FISHERS CANYON CREEK CHANNEL IMPROVEMENT PLANS

EL PASO COUNTY PCD
FILE NO.: CDR246.

DESIGNED BY: DCM
DRAWN BY: LWM
CHECKED BY: DCM
DATE: 12/18/2024

FISHERS CANYON CREEK
CHANNEL IMPROVEMENT PLANS
EL PASO COUNTY, COLORADO
COVER

SHEET
C1.3

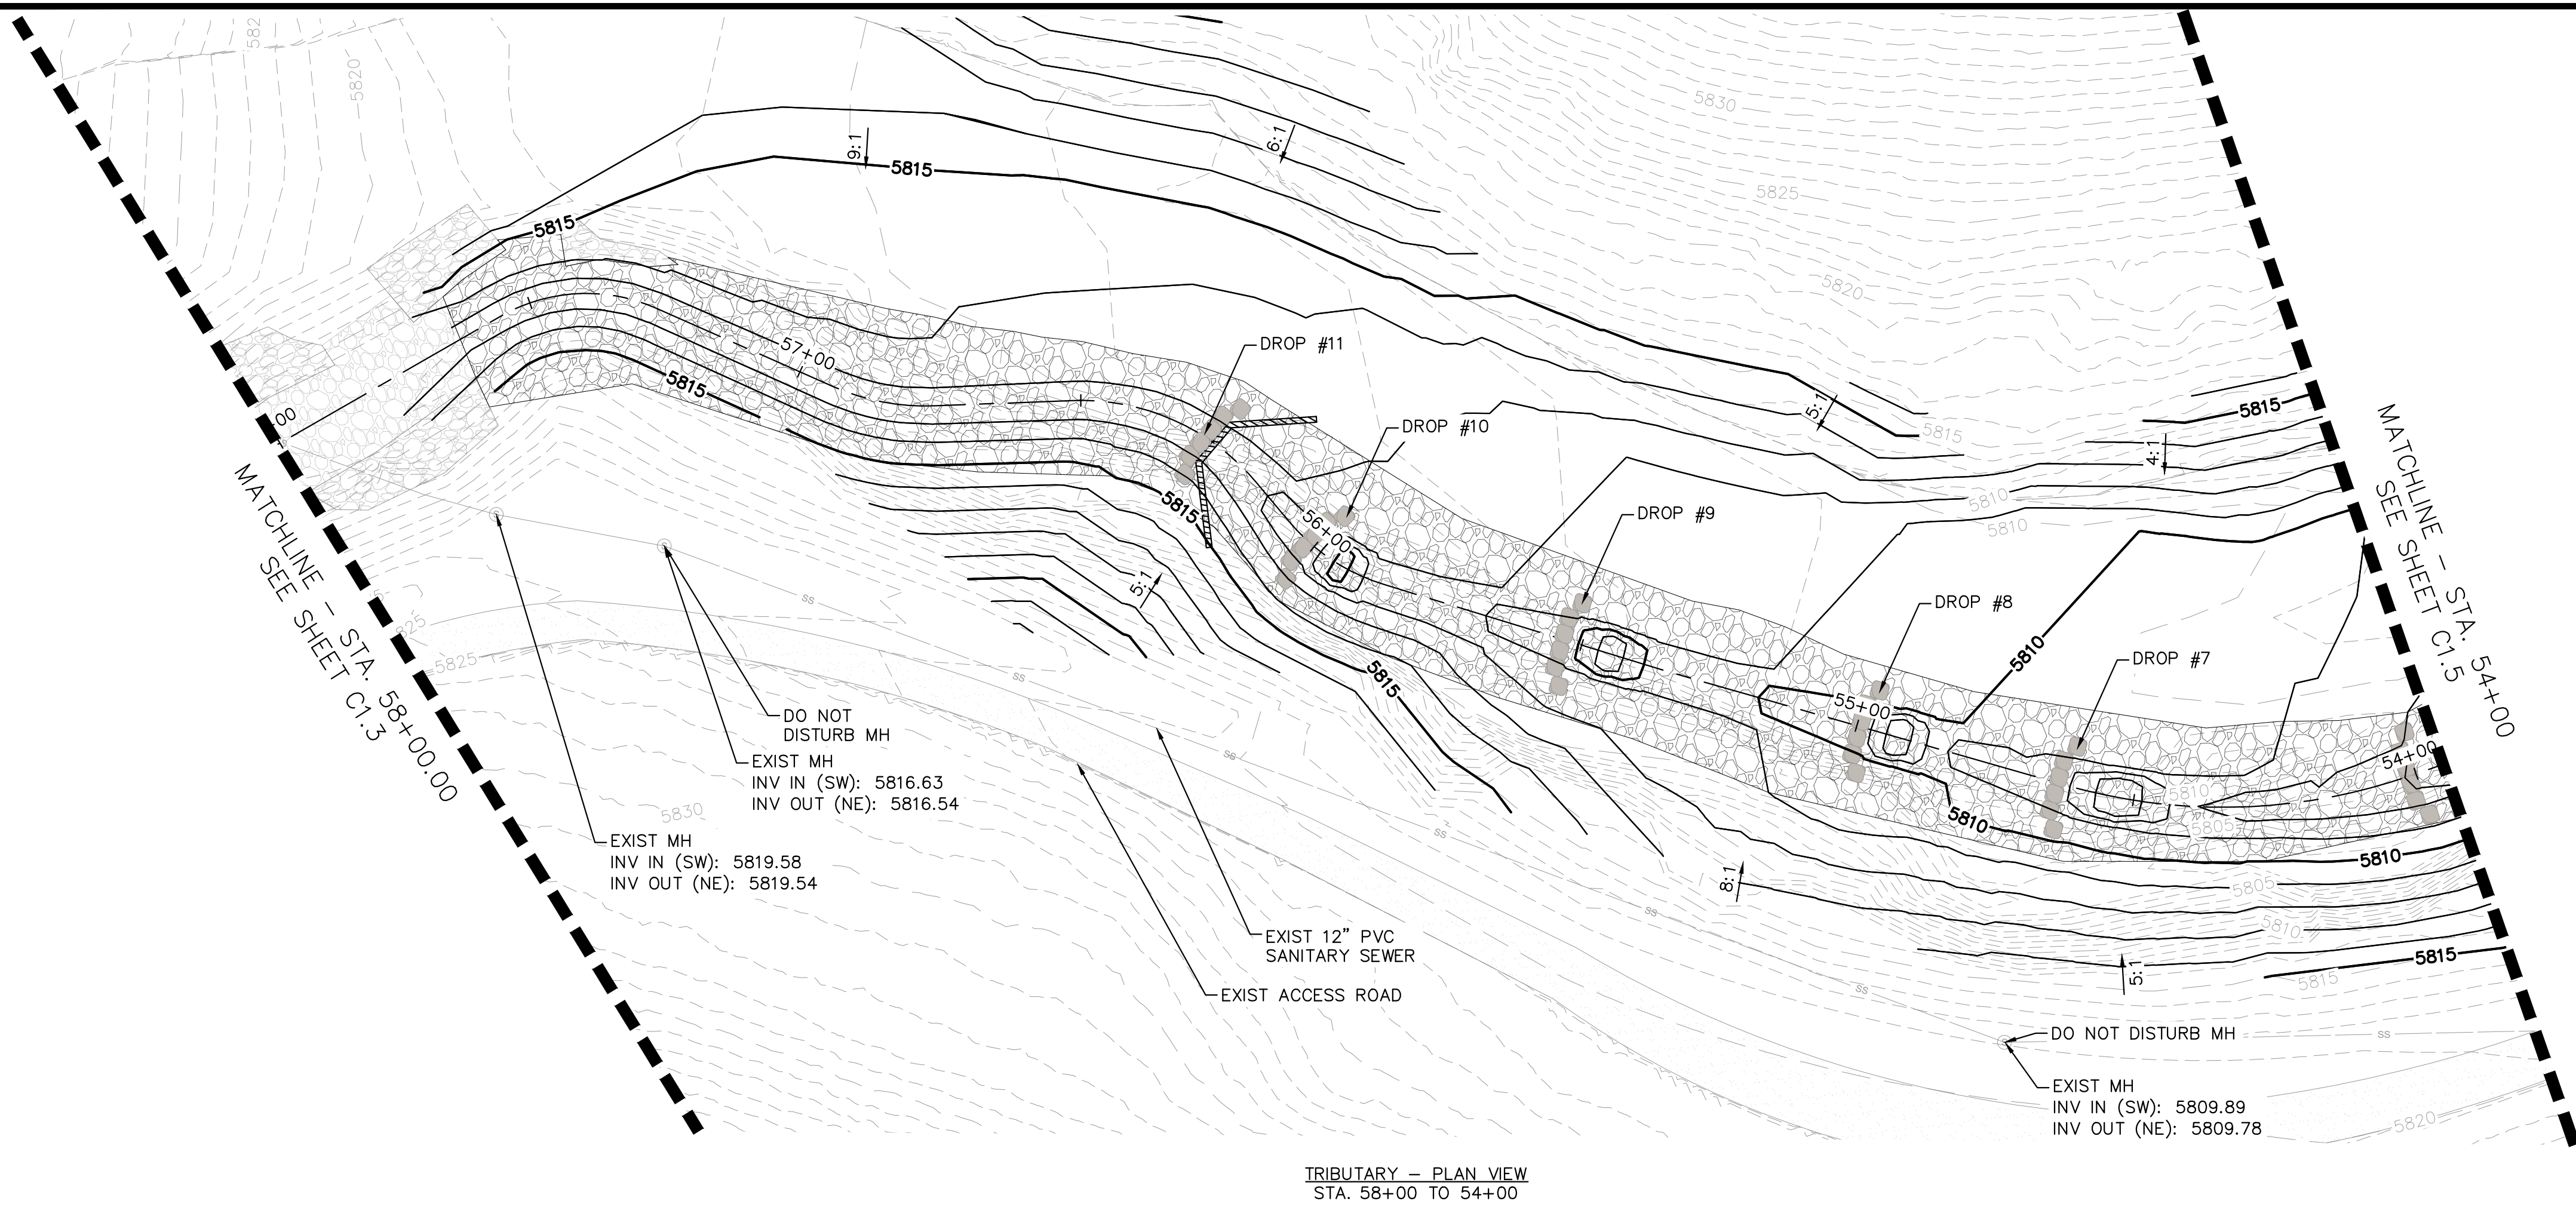
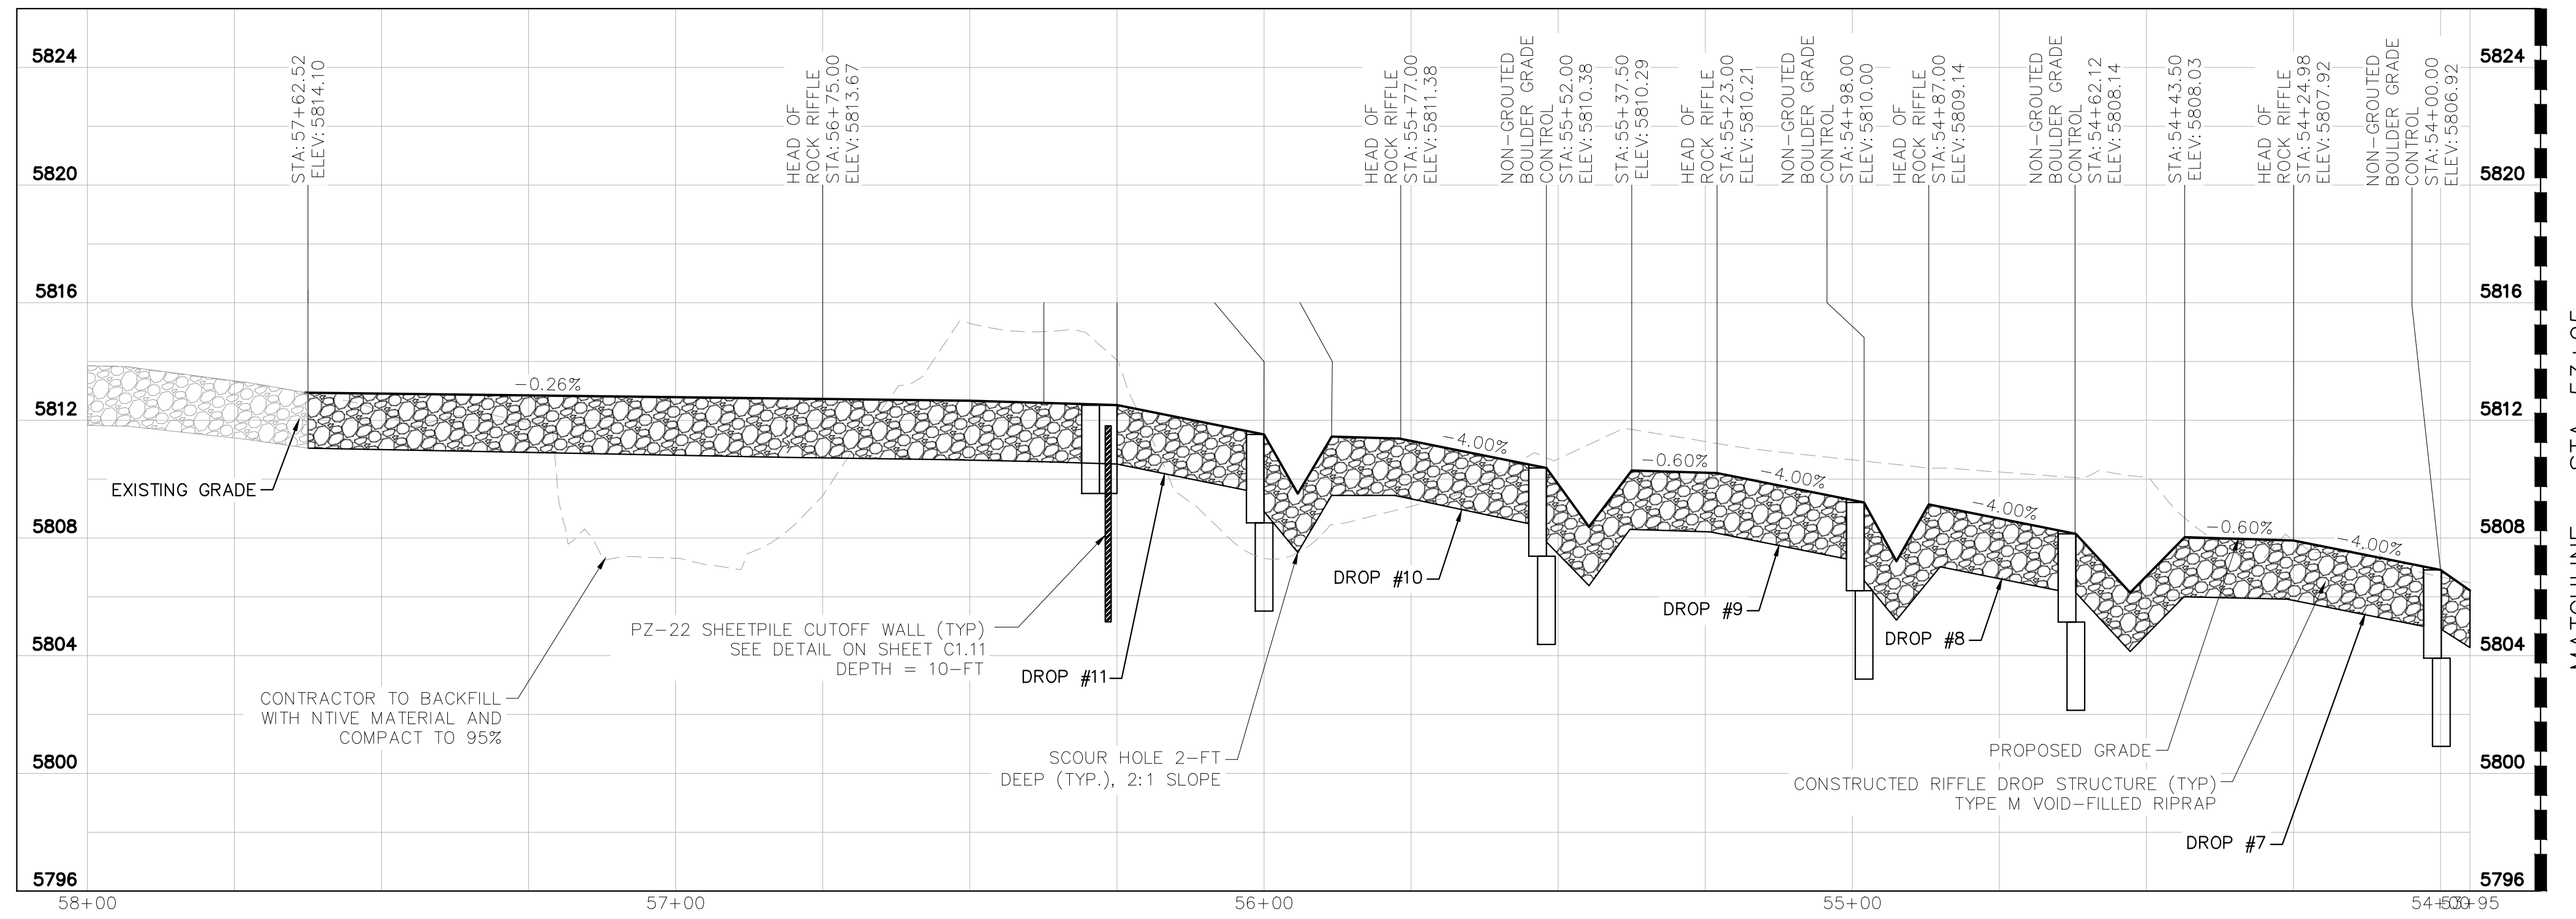
comments were provided on the subdivision regarding the proposed outfall of the pond. Please show the proposed outfall protection and how it will tie into the proposed channel improvements.

Clarify that this is not to be constructed with the channel improvements.

The subdivision drainage report also indicates that the pond spillway rundown will extend to the channel. Please show how it will tie in to the channel improvements proposed.

MAIN CHANNEL DROP STRUCTURE #1

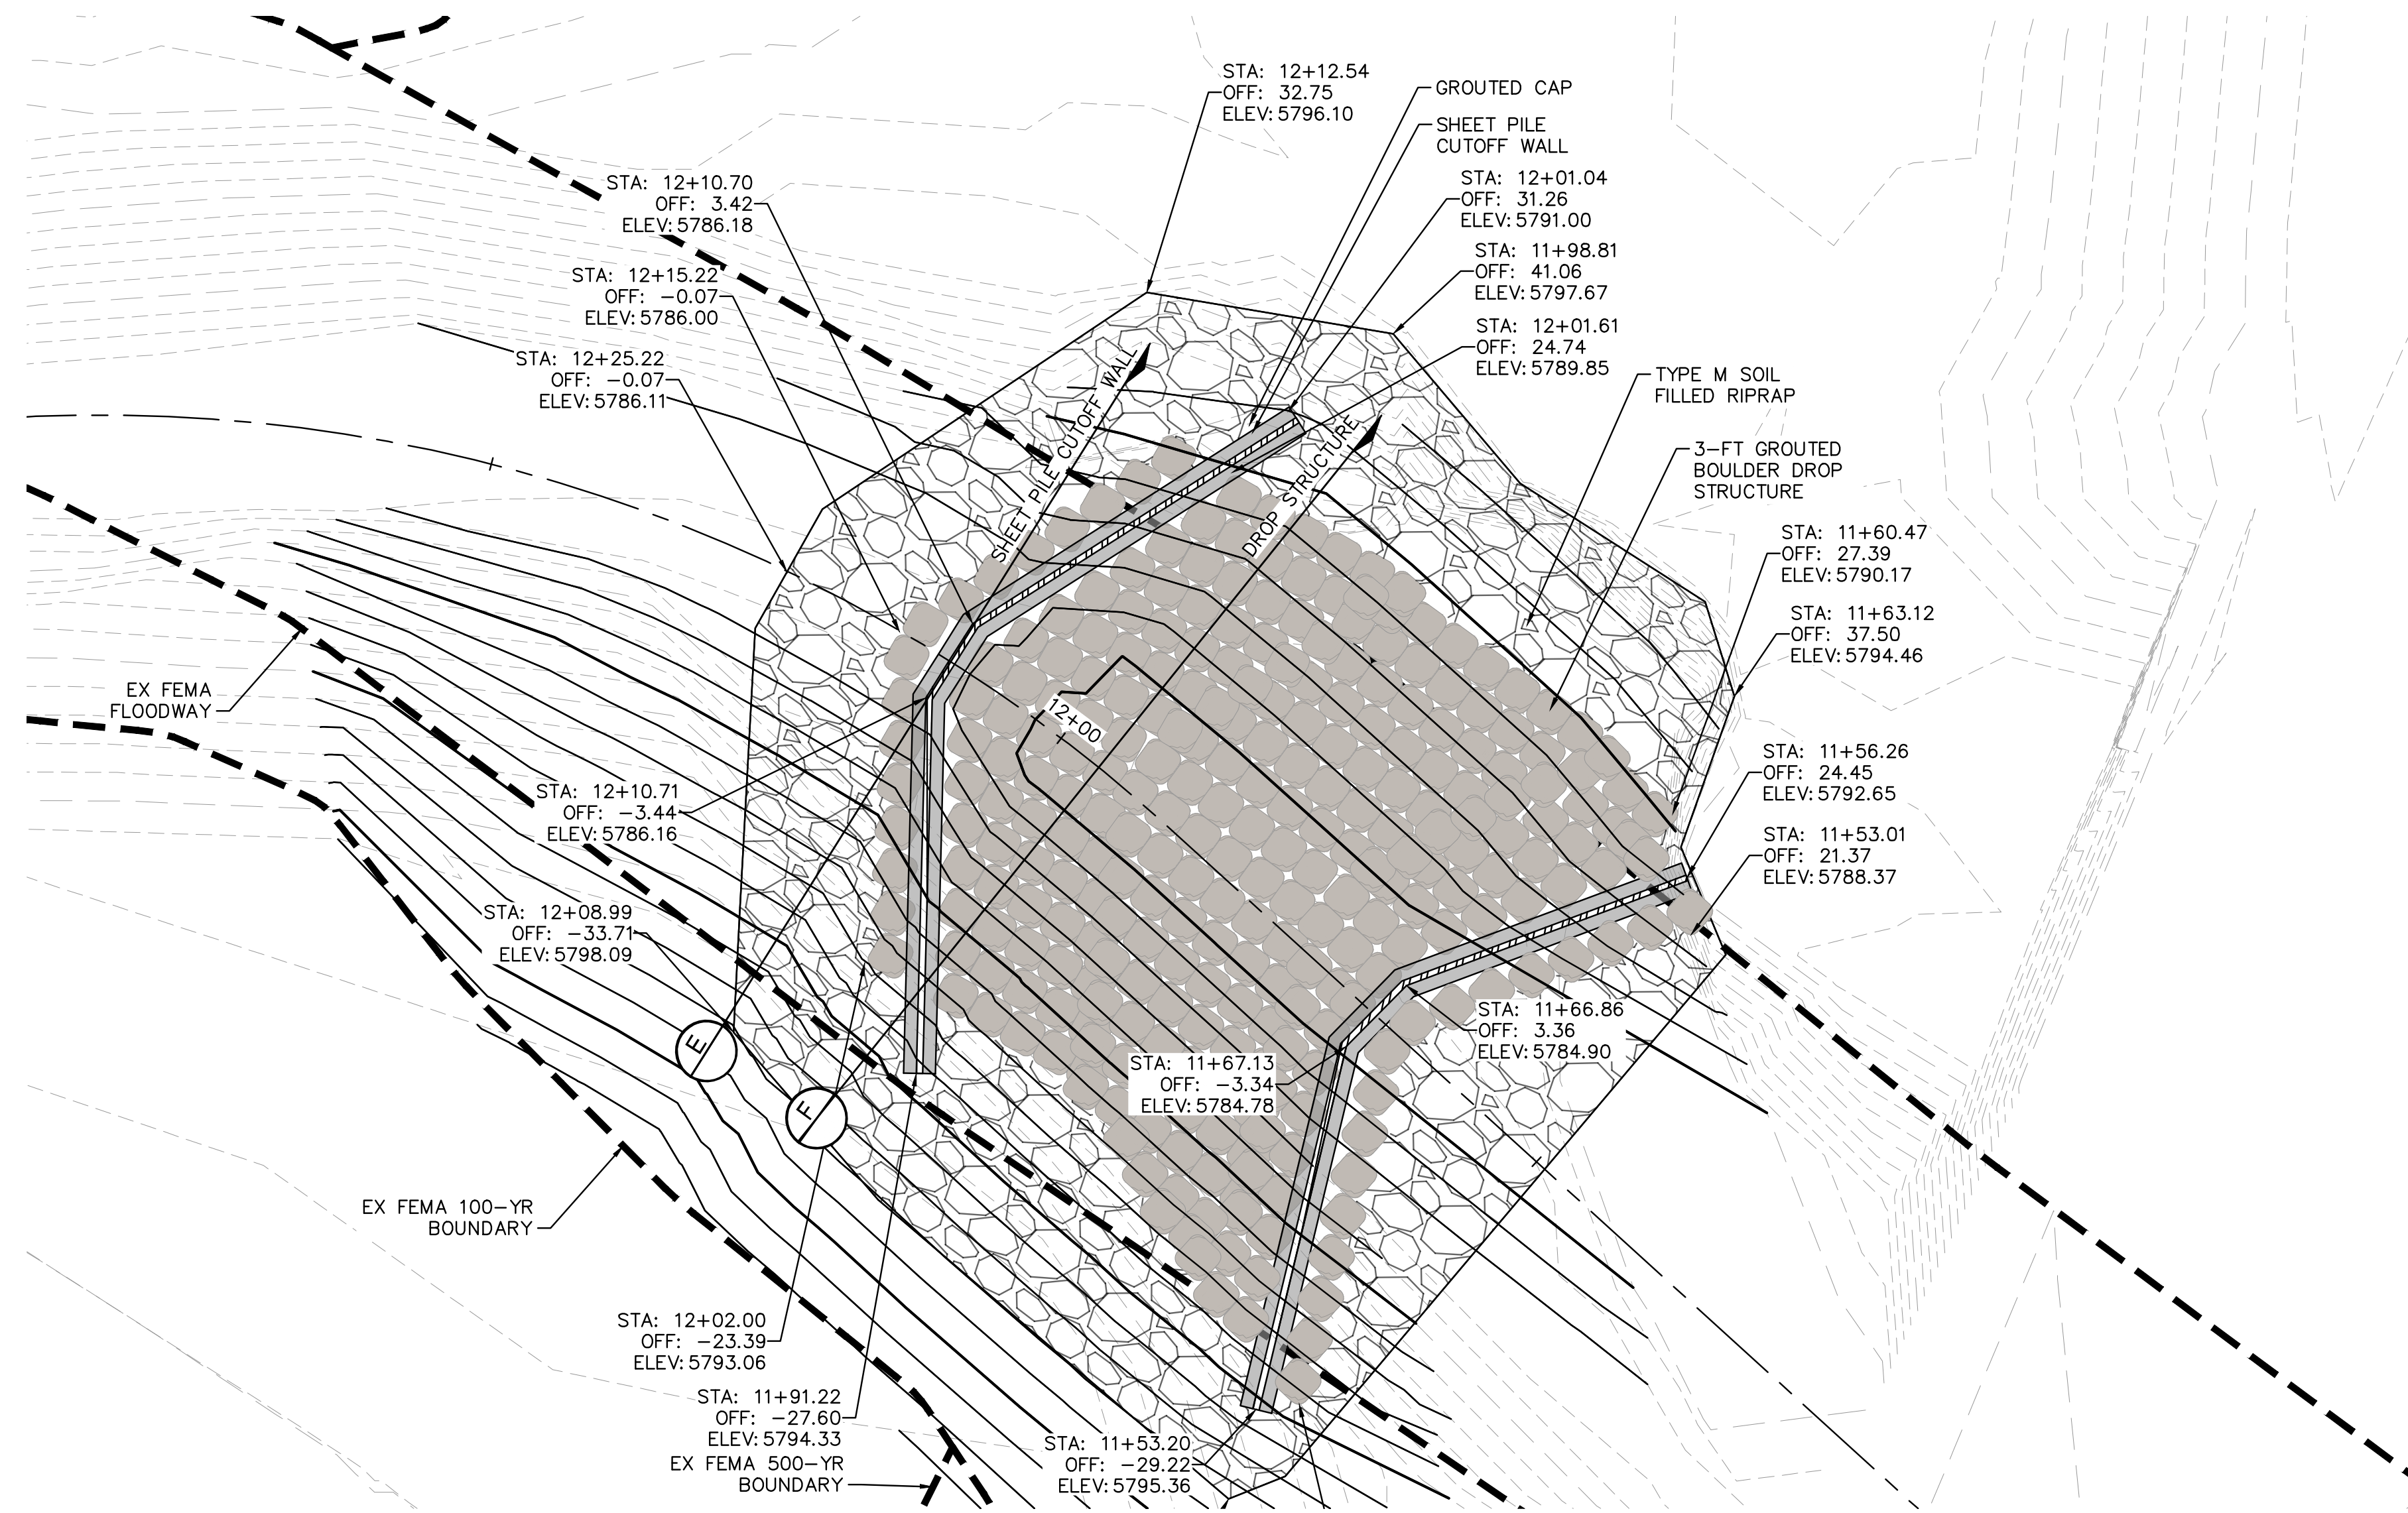
show/label both floodway and floodplain
